From: Plant, Tom - Communities <Tom.Plant@Oxfordshire.gov.uk>
Sent: 22 January 2020 10:28
To: Shona King
Cc: DC Support
Subject: 19/02001/F - The Chaff Place High Street Bodicote

I have looked at the applicants Transport Statement and looked again at the site plan and still conclude that the access as proposed for two dwellings is inadequate due to its width, lack of inter-visibility for pedestrians and inadequate visibility envelope without evidence to suggest a reduced envelope would be acceptable at this proposed intensified access.

JOB TITLE		Bodicote, Banbury		CLIENT		Mr Alex Watson	
DRAWING TITLE							
Site Access Visibility Splays							
SCALE	DRAWN BY	DATE	DRAWING No	REVISION			
1/250@A3	JA	March2020	21487-03

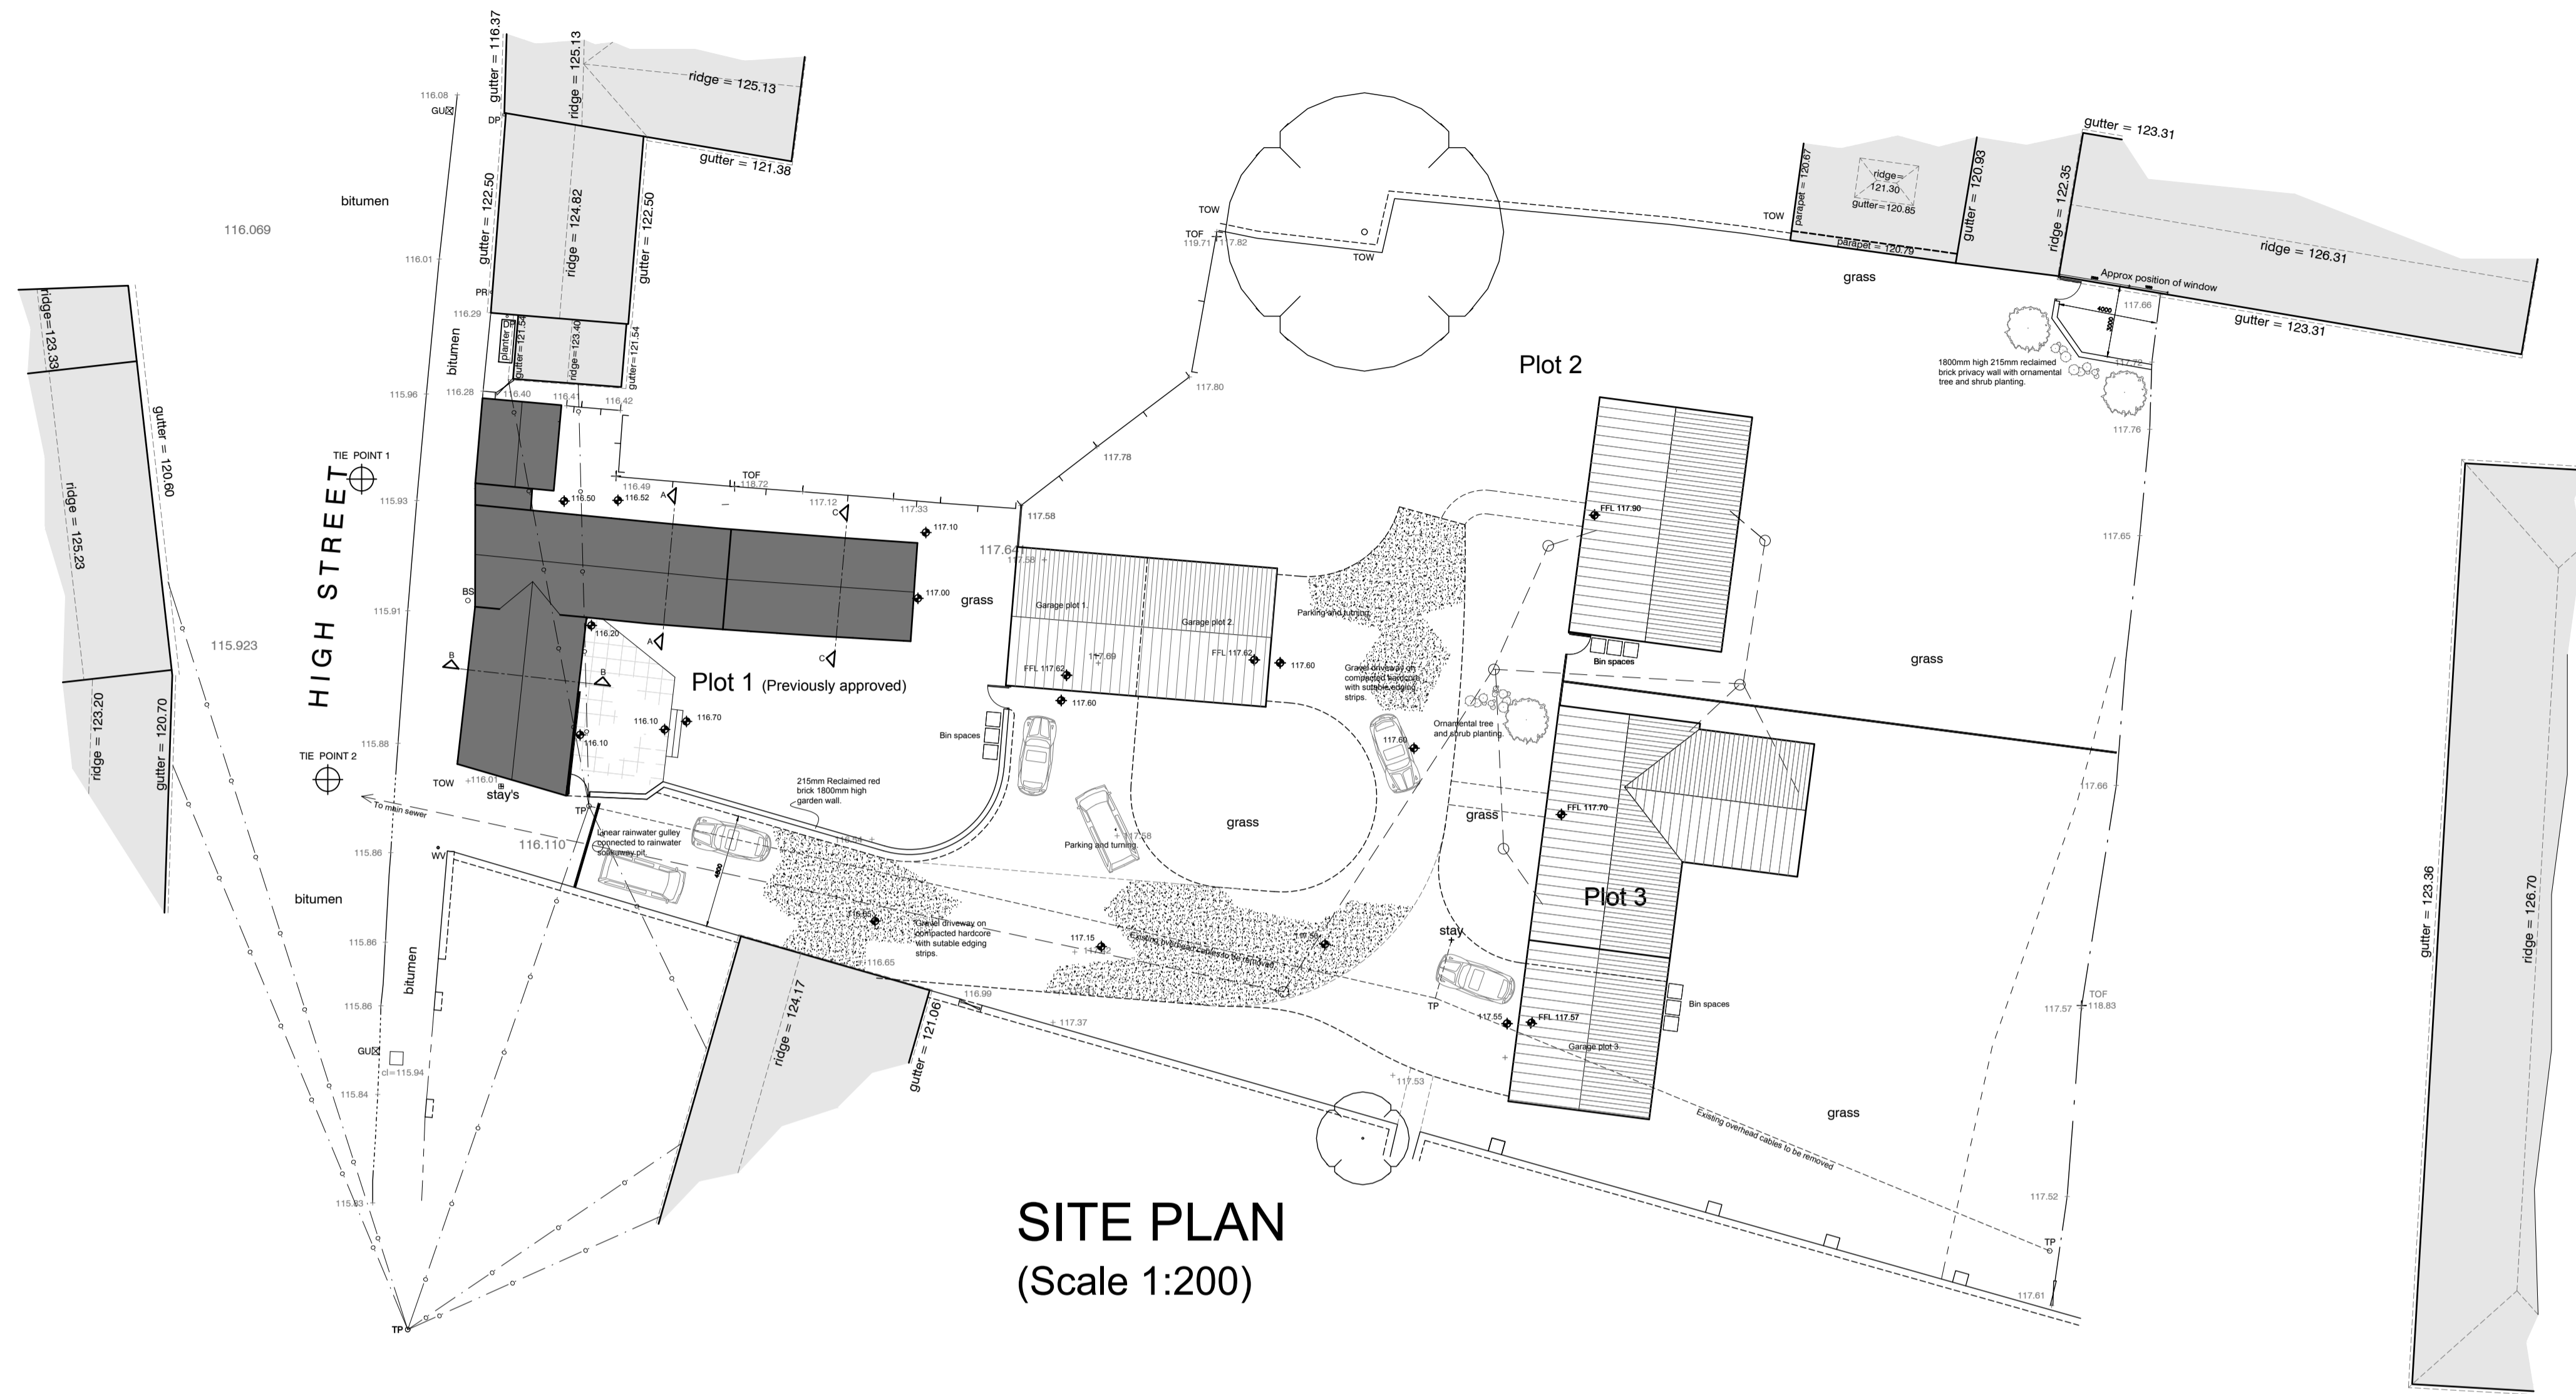
Finally, the application appears to lack details of what the achievable visibility is for this proposed intensified access in the form of a plan (that is assumed the site access was acceptable). Without a speed survey it is assumed Manual for Street (MfS) 1 and 2 standards are to be applied.

The updated Transport Statement received December 2019 states that acceptable visibility can be achieved from the site. However I dispute that this is possible as this has not been shown in plan form. Were a plan to show a visibility splay that accords with MfS, I believe due to the curvature of Highstreet, this visibility splay passes through objects including dwellings south of the site, consequently a visibility splay that is in accordance with MfS is not achievable. Had the applicant conducted a speed survey, this may then inform a reduced visibility envelope. However this hasn't been demonstrated and as such MfS has been applied in this assessment of the visibility envelope from the site proposed access.

**SITE PLAN**  
(Scale 1:200)

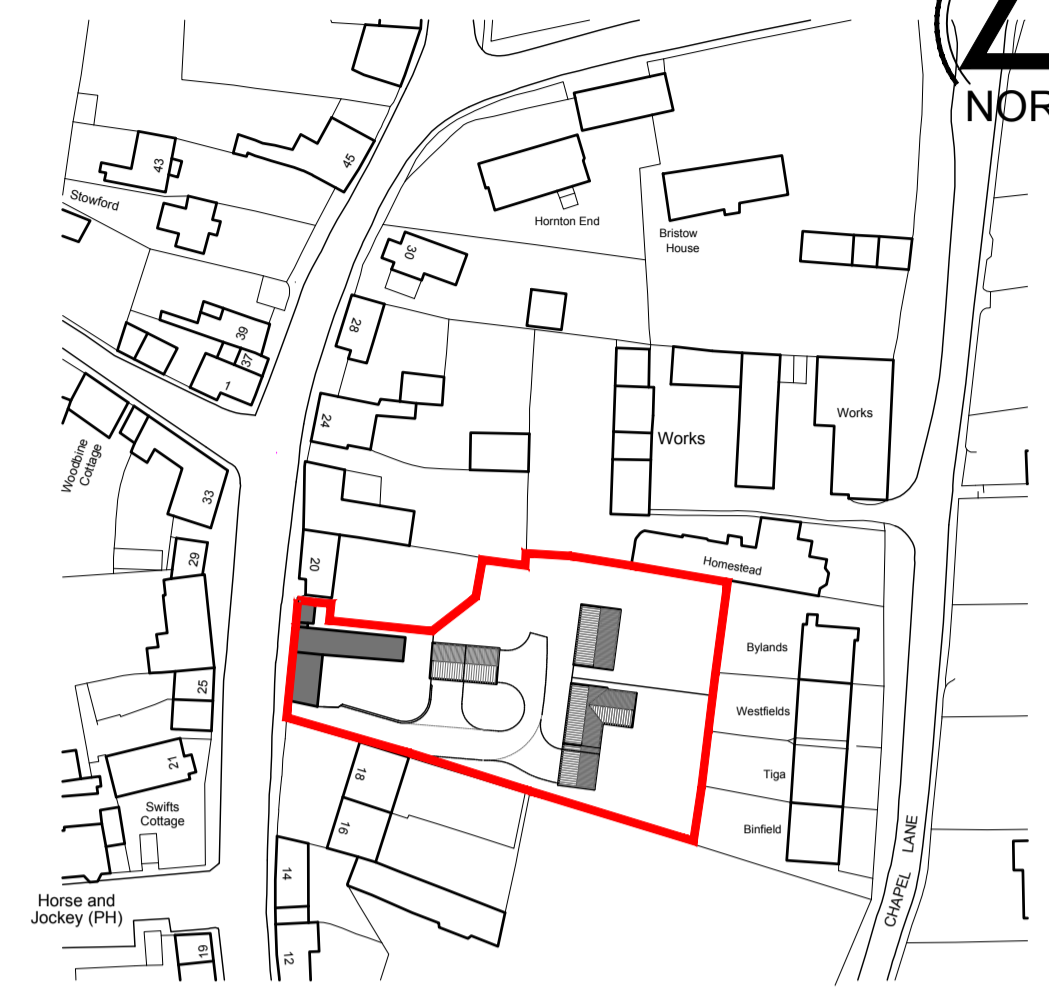
Due to the limited width of the proposed intensified access, conflict will arise should two vehicles attempt to use the access at the same time. The lack of visibility into the site has the potential of requiring one of the vehicles to reverse either back into the site (to allow an accessing vehicle to leave the network), or the opposite (with an egressing vehicle taking priority) occurring, forcing the accessing vehicle to reverse back out across the footway and into the highway. As a result of this proposed inadequate access, and with little or no pedestrian inter-visibility, this constitutes an unacceptable highway and pedestrian safety risk.
